**SYDNEY INTERNATIONAL CONVENTION,
EXHIBITION AND ENTERTAINMENT PRECINCT
(SICEEP)**

**DARLING SQUARE
NORTH PLOT & PUBLIC DOMAIN**

ACCESS REPORT

**ADDENDUM REPORT FOR STAGE 2 STATE
SIGNIFICANT DEVELOPMENT APPLICATION
(SSDA 10)**

**NORTH PLOT AND DARLING SQUARE
ACCESS AND LEVELS**

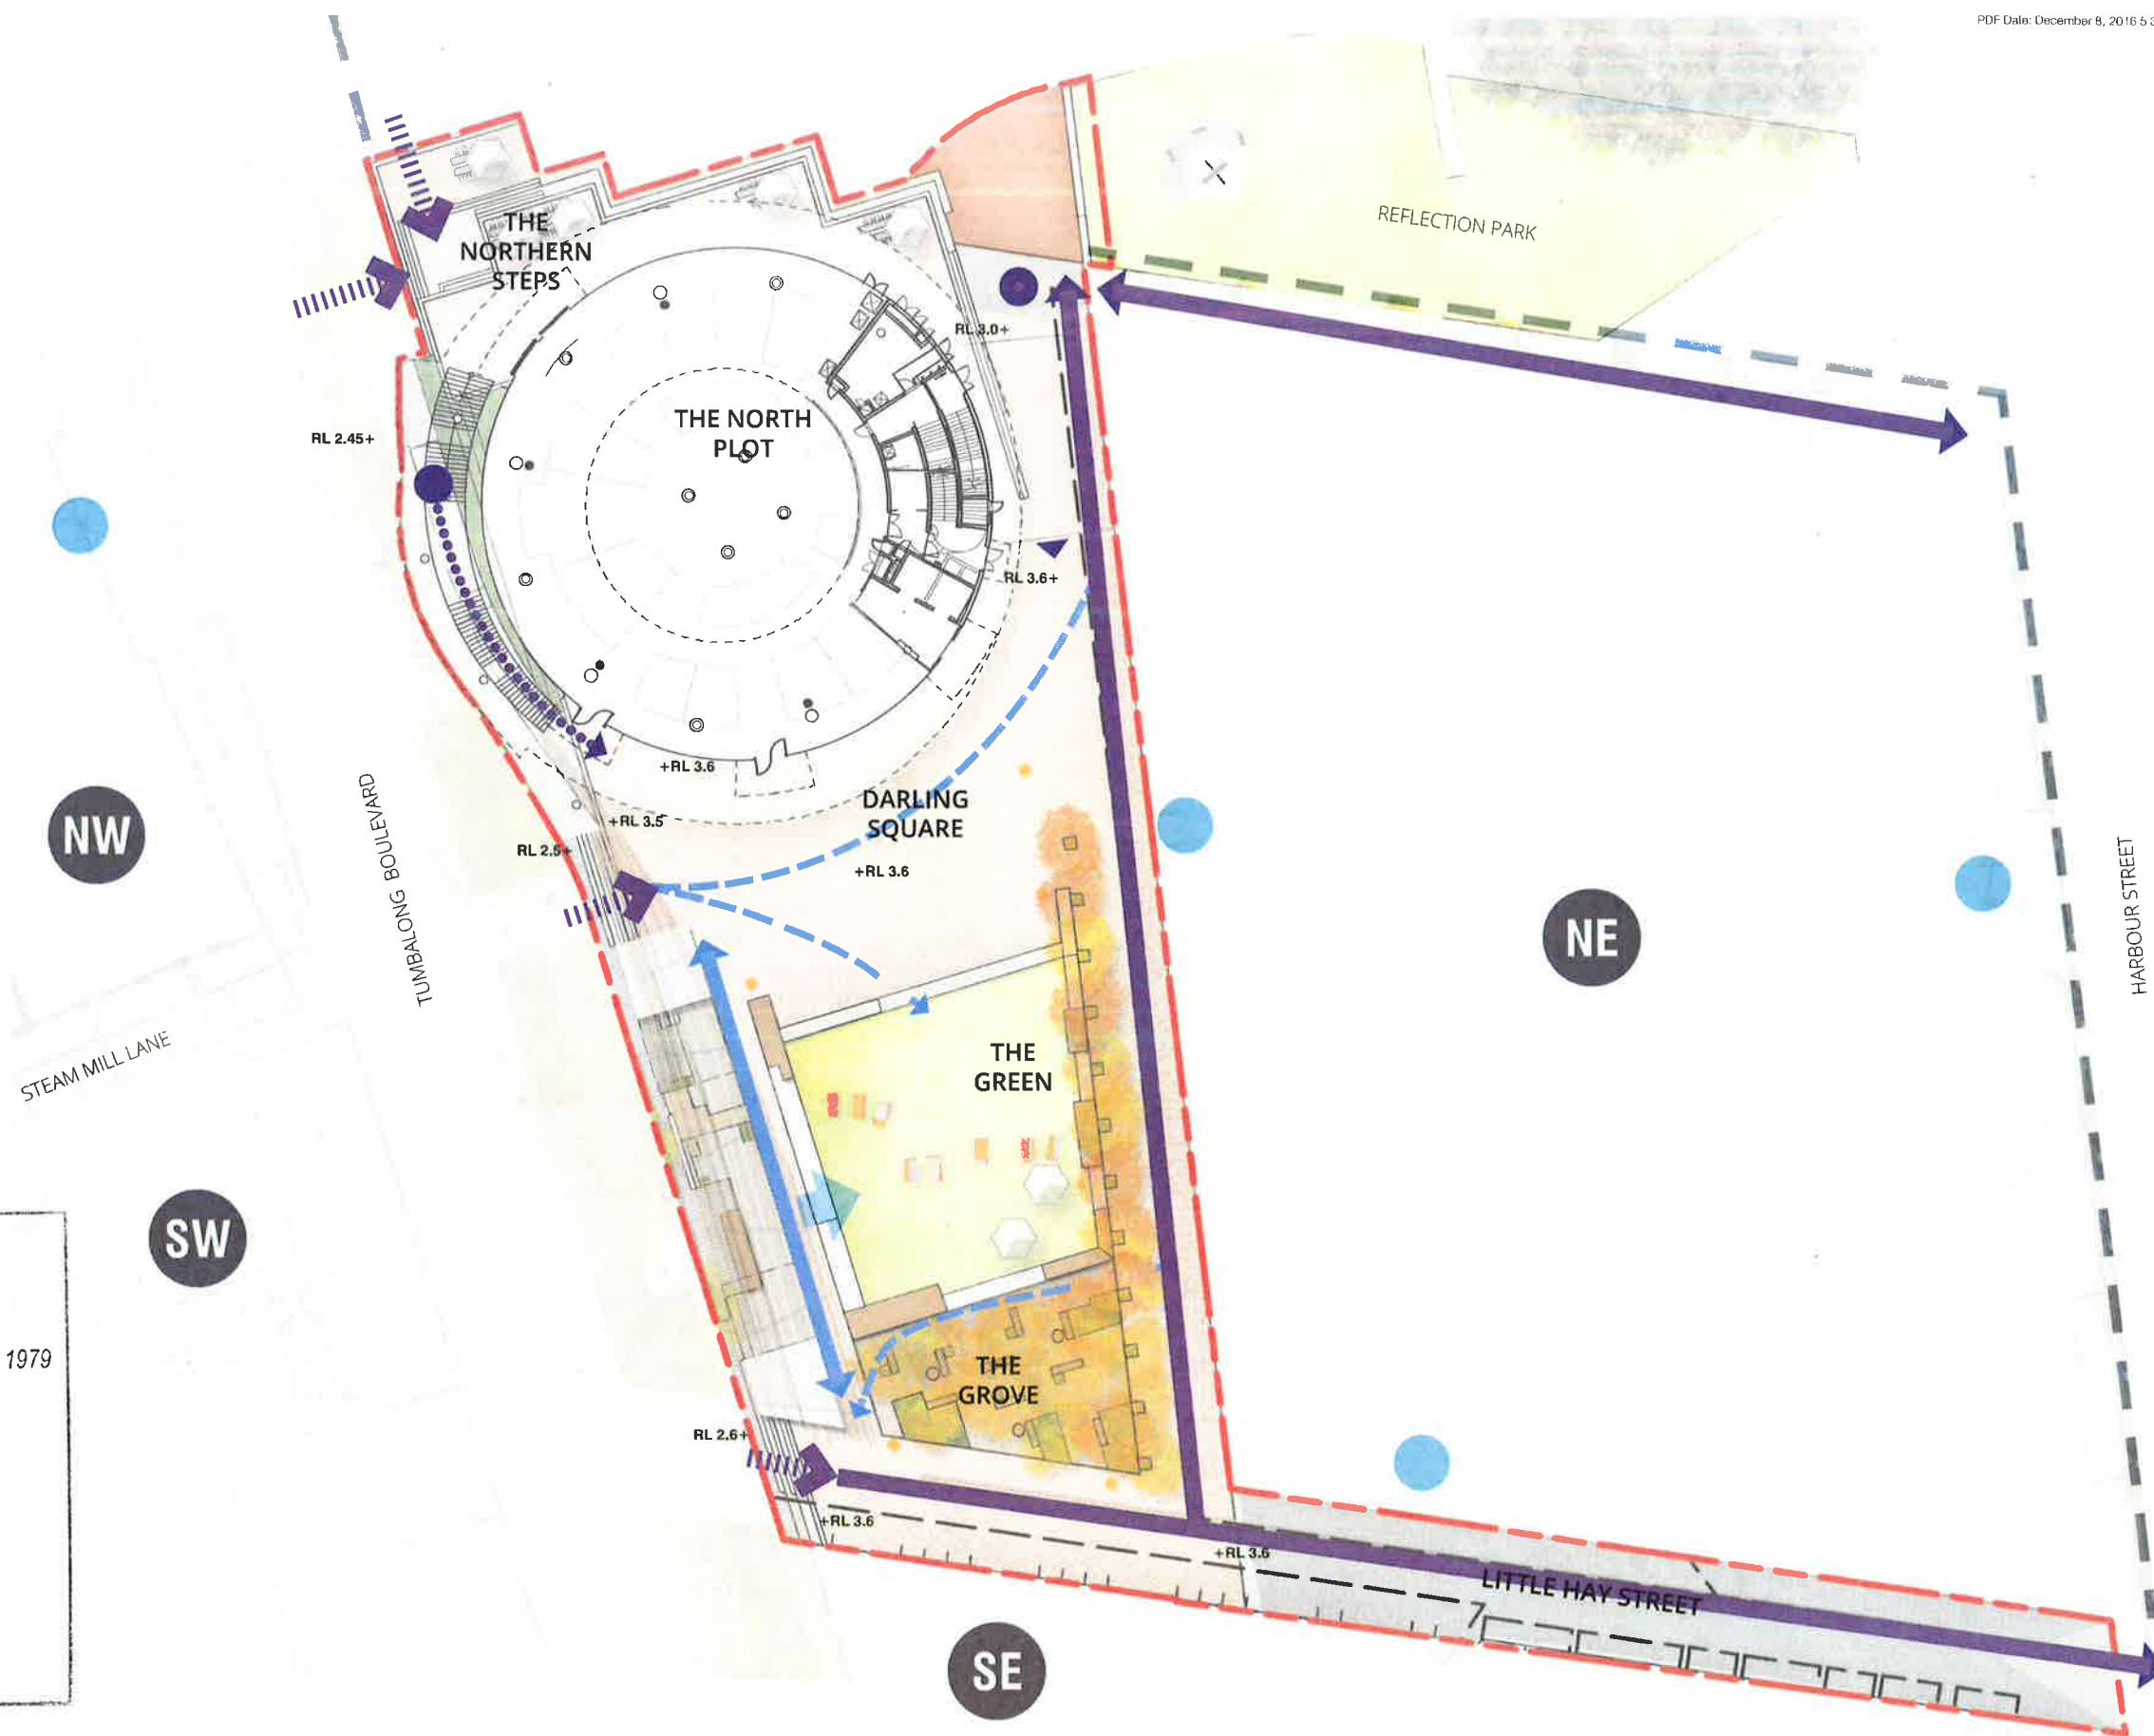
There is an external stairway near the intersection of The Boulevard and Little Hay Street. There are external stairways on the northern and southern sides of the northern retail pod at The Square.

Compliance with AS1428.1(2009) and AS1428.4.1(2009) at each of the above stairways will be achieved in detailed design. Compliance with AS1428.4.1(2009) would include the provision of suitable flooring at the landings to enable the installation of warning tactile ground surface indicators ('TGSIs'), as well as the provision of handrails on each side.

There is an external graded pedestrian walkway that runs alongside the western edge of the North Plot building from the intersection of The Boulevard and Factory Lane up to The Square. The walkway will have a gradient of 1:22, which is a suitable gradient for compliance with AS1428.1(2009).

The above walkway has suitable clear widths and level landings at suitable locations for compliance with AS1428.1(2009). The above walkway will be capable of providing a continuous accessible path of travel between the Boulevard and The Square within the meaning of AS1428.1(2009).

It is noted that the most direct pedestrian path of travel between Little Hay Street and The Square, at RL3.6, and the Boulevard, at RL2.6, will be via any of the three external stairways at the western edge of The Square. The external 1:22 walkway discussed above will function as the accessible path of travel for those users that do not have the ability, or do not wish, to use stairs. It is to be noted that, for those users, the external 1:22 walkway is located at a beeline distance of approximately 50 metres from the furthest stairway. This may disadvantage those users for whom travel distance is an issue.
